Application No: BE/59/21/PL
Site Address: 339 Chichester Road Bersted PO21 5AN
Description of works: Replacement of blockwork boundary wall with fence and new vehicular access (resubmission of BE/149/21/PL).

Thank you for your internet representation made on 2nd June 2021 which has been recorded as an objection with the comments as follows:

SITE PLAN - SHOWING VISIBILITY SPLAYS
1:500 SCALE (at A3)

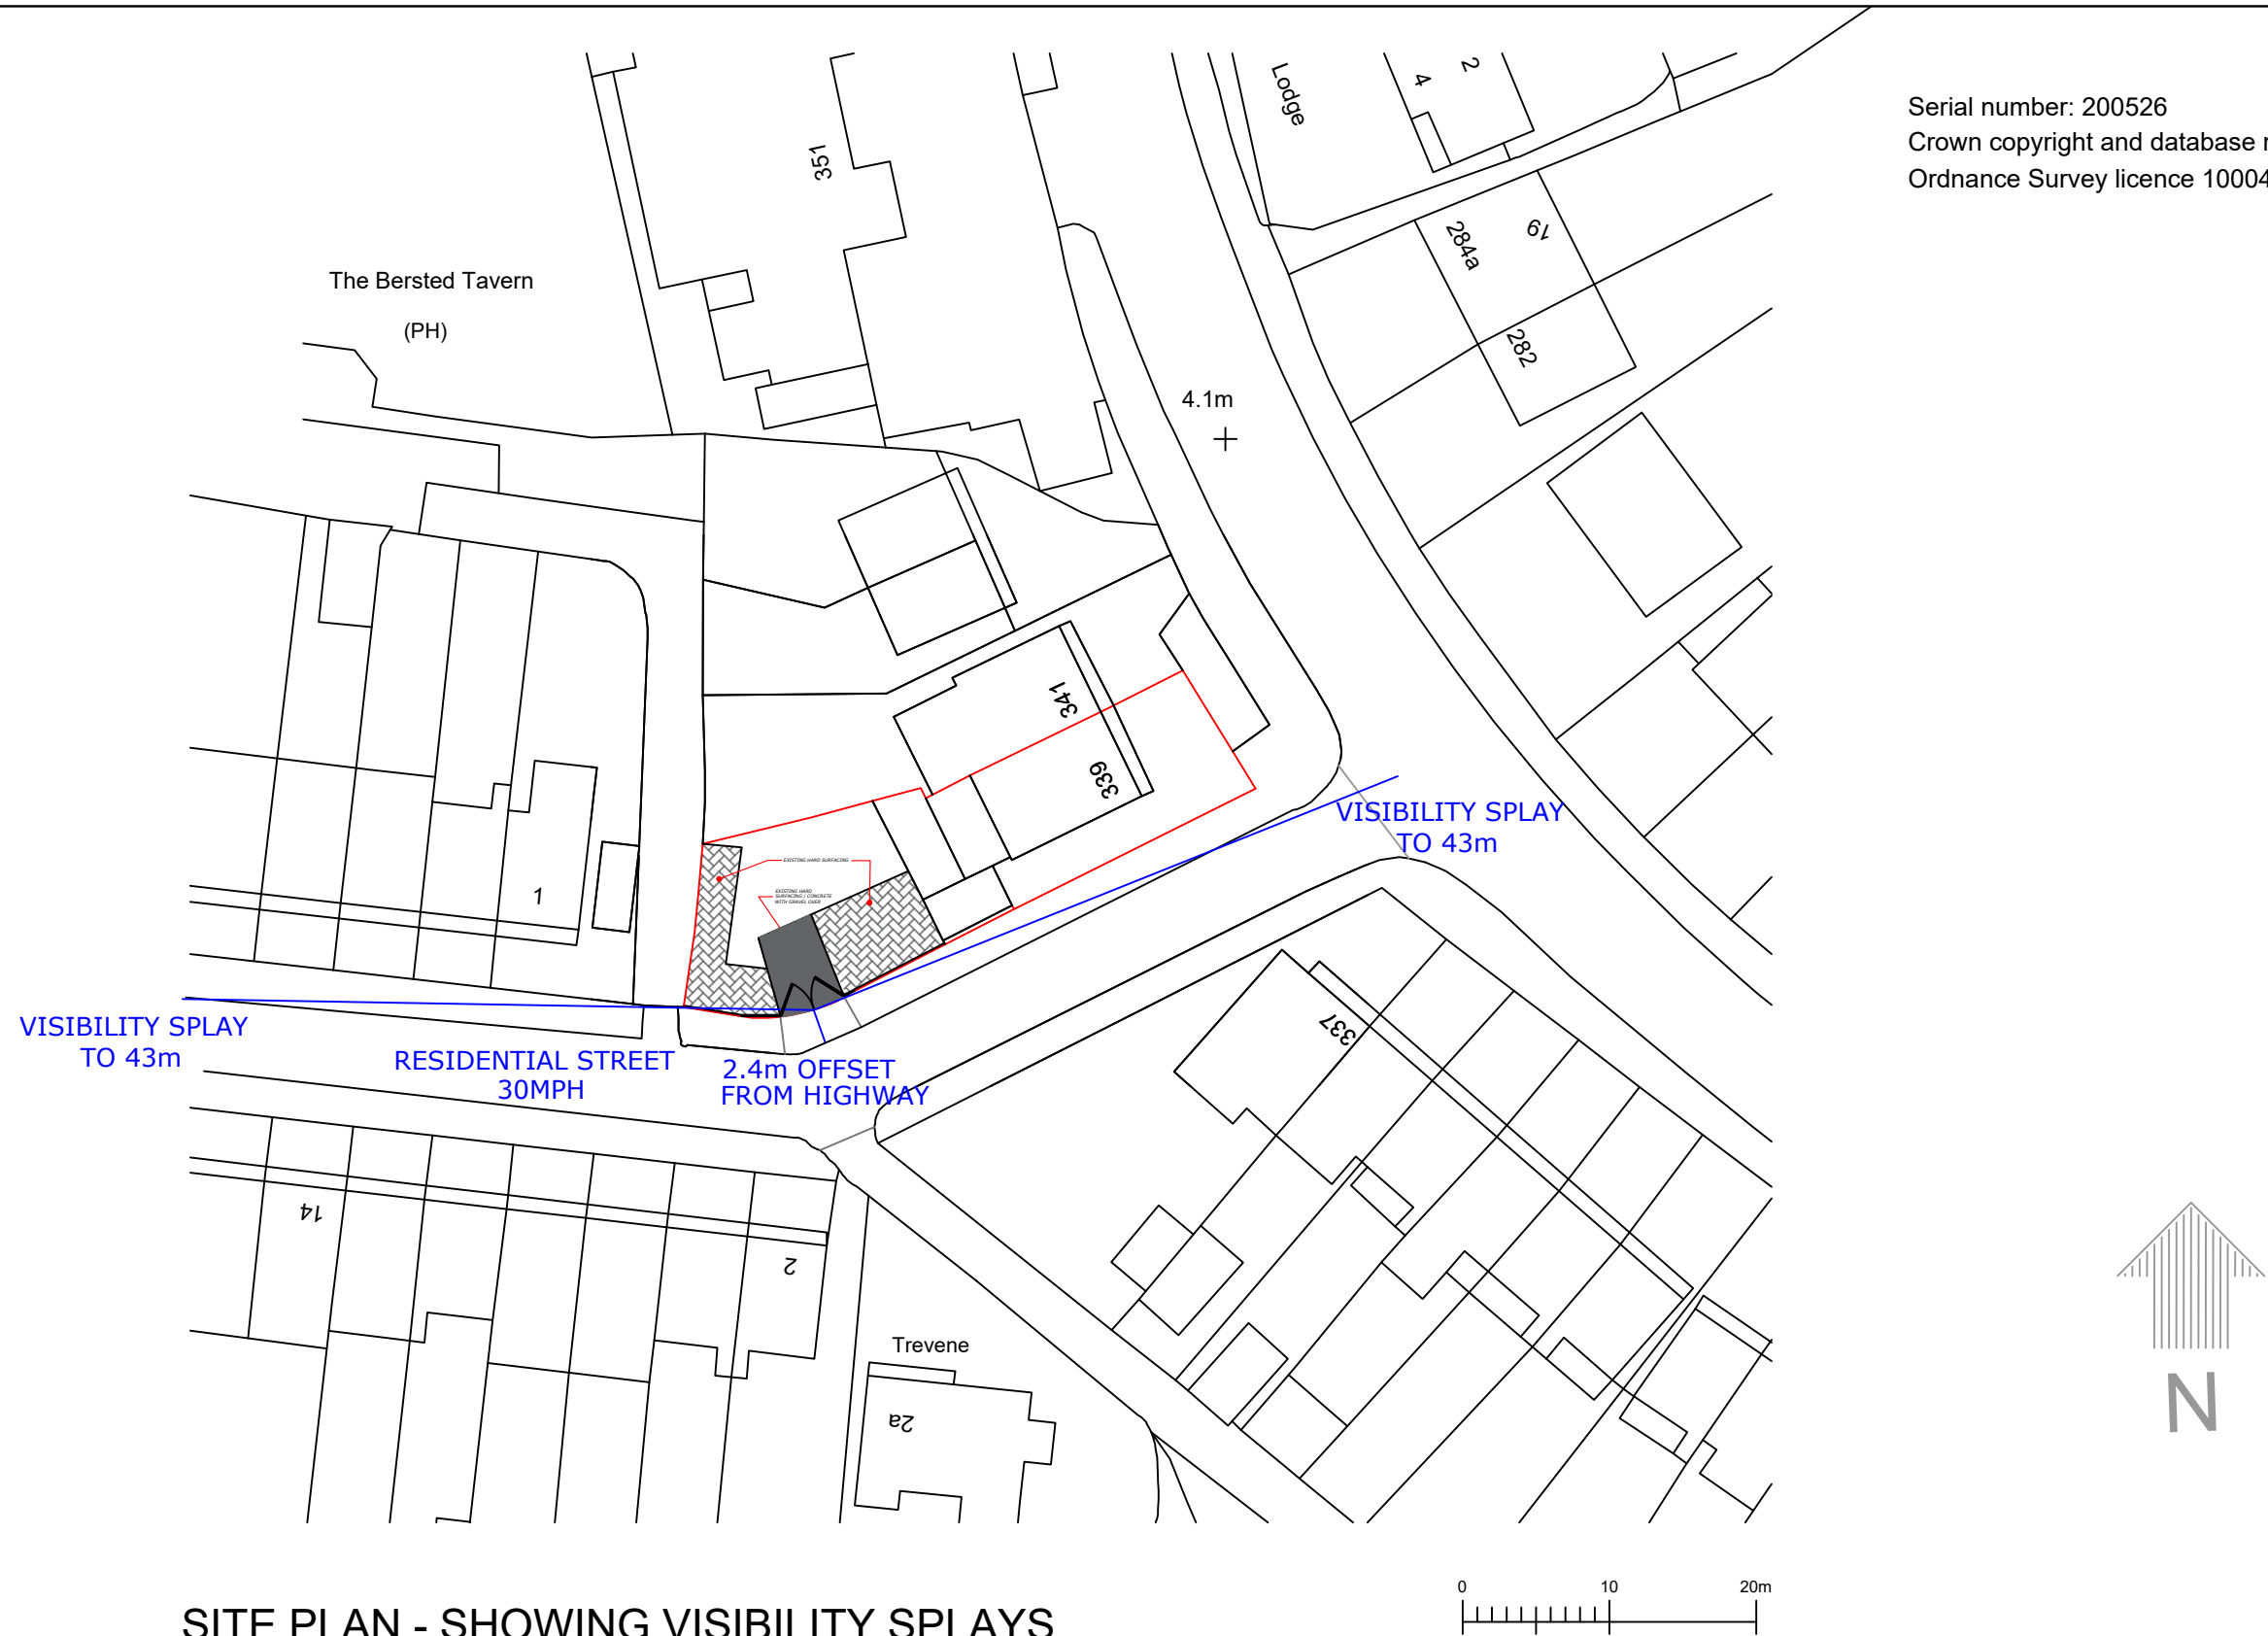
Highway Safety - the proposed new vehicular access is on a bend and the plan showing the visibility splay does not take into account that residents cars are parked near the bend which makes it impossible for the visibility splay of 43m to be achieved. It is a safety issue for pedestrians, children and cars if this access is allowed. Bedford Avenue, where the proposed vehicular access is, is also subject to a traffic mitigation scheme.
